The Sod Guy – Sales Lot @ Lot 1 in Appaloosa Highway 24 Subdivision Filing No. 2
Letter of Intent

Site Location: Lot 1 in Appaloosa Highway 24 Subdivision
Colorado Springs, CO 80915

File No: AL-19-014

**THE SOD GUY - SALES LOT**  
**SITE PLAN**

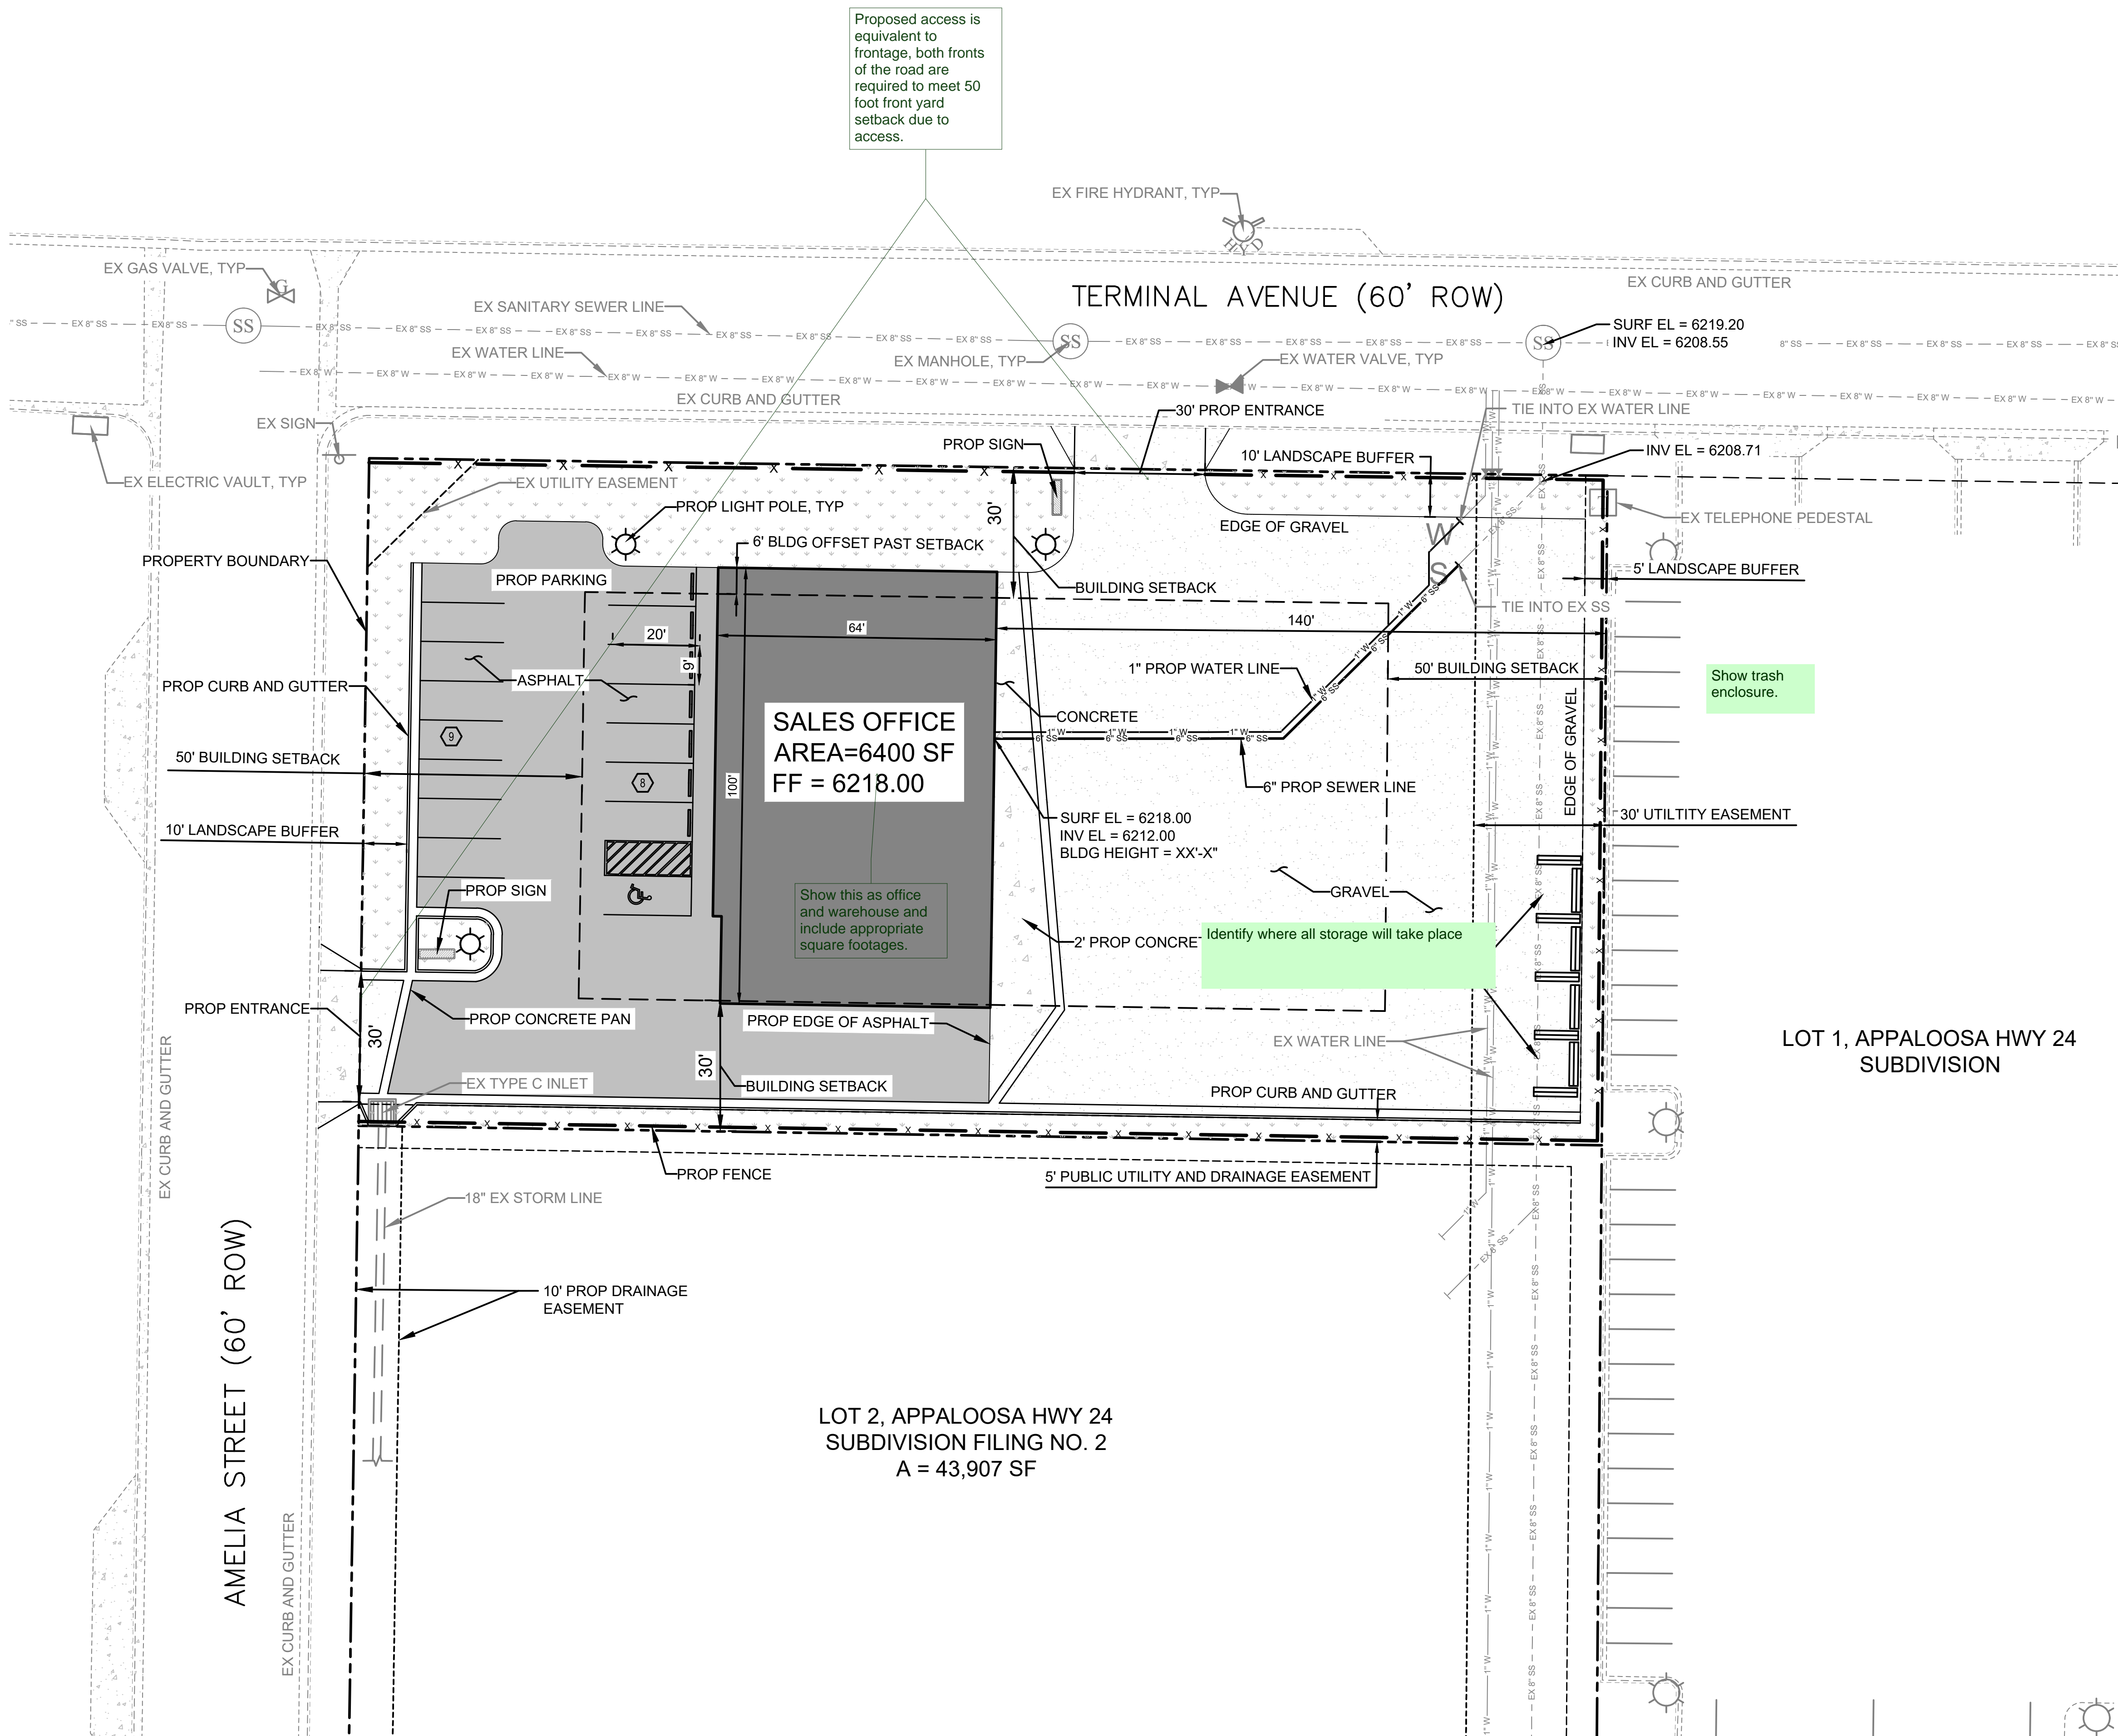
Access points are equivalents to frontage in commercial/industrial zoning districts. Both frontages will require the 50 foot setback requirement.

This project includes two access points to the site; one from Amelia St. and one from Terminal Ave. All installations on site are minor and the construction timeline is aggressive. The proposed building on site is of wooden construction. No large equipment for installation is anticipated. As a result, no additional traffic control shall be provided.
